Bord na Móna

Drehid Waste Management Facility – Further Development Response to Third Party Observations

Document Reference	11290 Drehid_Third Party Observations Response
Client:	Bord Na Mona
Project Reference	11290
Client Address:	Main Street, Newbridge, Co.Kildare W12 XR59
Report Date	13/09/2023

Landscaping Plan

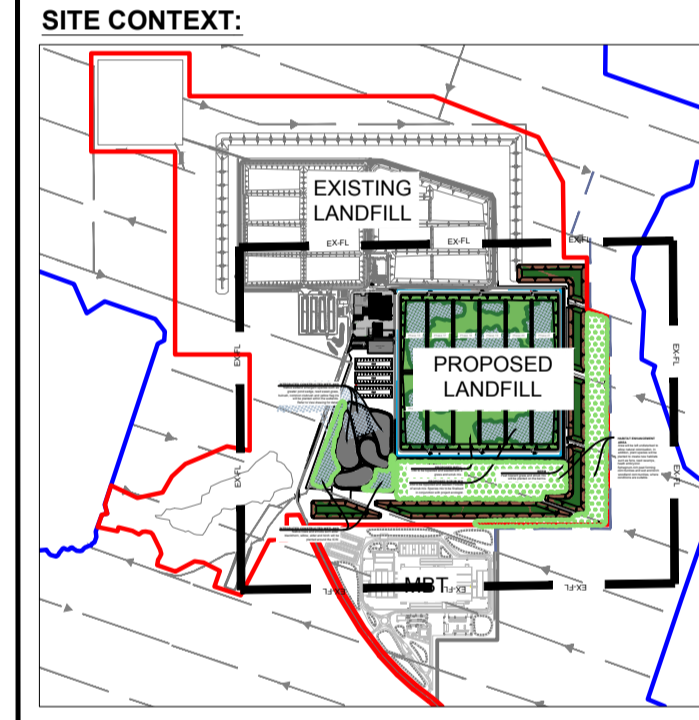
Prior to the commencement of development, a revised Landscaping Plan shall be submitted for the written agreement of the Planning Authority outlining the following:

- a) *Sections across the site showing the elevation and extent of planting and mounds.*
- b) *Revised mounding proposals. A more organic and undulating mounding would be more in keeping with the rural location the waste facility is located in.*
- c) *Details regarding the species and quantities of plants proposed and how these will be managed.*
- d) *Details of the scrub mix proposed for the site,*
- e) *Details of the depth of topsoil proposed for the infill area.*
- f) *Details for the protection of the habitat enhancement areas shall be provided regarding the protection of these during construction and operation works.*

KCC have recommended conditions relating to habitat loss and minimising the removal of vegetation.

Response: The recommended condition is noted and Bord na Móna has no objection to this condition.

During the construction phase, all vegetation clearance will be kept to a minimum by the appointed Contractor. The work areas will be demarcated prior to the construction works commencing and no clearance of vegetation will be undertaken outside of the demarcated areas. Replanting of vegetation will be undertaken as outlined within the Landscape Plan (refer to Appendix 6-3 in the EIAR) and Habitat and Management Plan (refer to Appendix 6-3 in the EIAR). All replanting will be undertaken following consultation and agreement with the Planning Authority.

Further details in relation to the Integrated Constructed Wetland (ICW), such as wetland depth, planting densities and operational maintenance can be provided to the Planning Authority, if required.
